**PROPOSERS RESPONSE**

**GOVERNMENT AGENCY  
AND  
PUBLIC SUBMISSIONS**

**PROPOSED TOURIST RESORT  
AT  
“LOT 490” CASUARINA WAY  
SOUTH KINGSCLIFF**

**DECEMBER 2010**

Figure 1. Revised Coastal Hazard Lines provided by Tweed Shire Council 2010

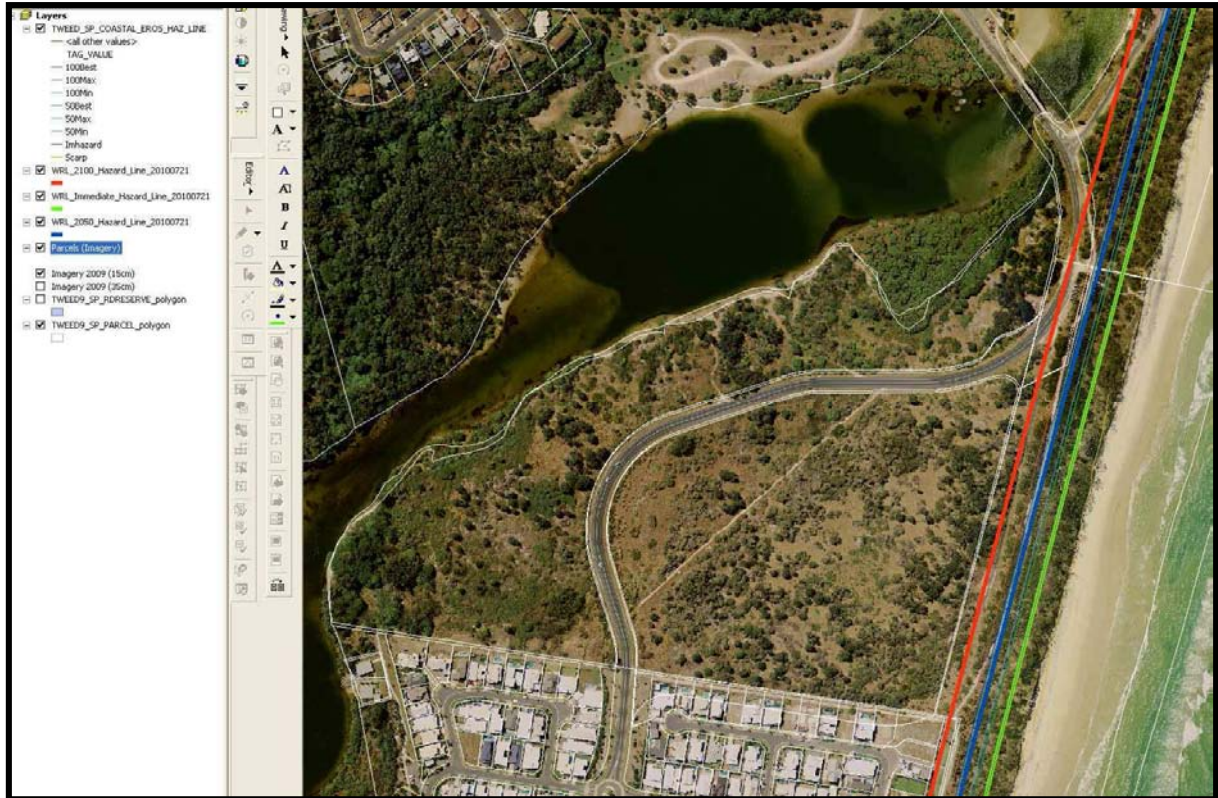
***As advised in the DECCW submission the proponent is to further consult with Tweed Council in relation to compliance with minimum requirements for fill and floor levels and coastal hazard impact lines.***

*"An image showing the revised hazard lines including an immediate hazard line, 2050 hazard line, and 2100 hazard line was provided by Jane Lofthouse on the 4<sup>th</sup> August 2010. The revised hazard lines are shown as being further landward than those provided in the previous Tweed Shire Coastline Hazard Study 2002.*

*We have amended the Coastal Hazard Assessment so that the revised hazard lines (2010) have been overlaid onto the new development layout. ....amendments (to the project plans) were not required for coastal hazard purposes.*
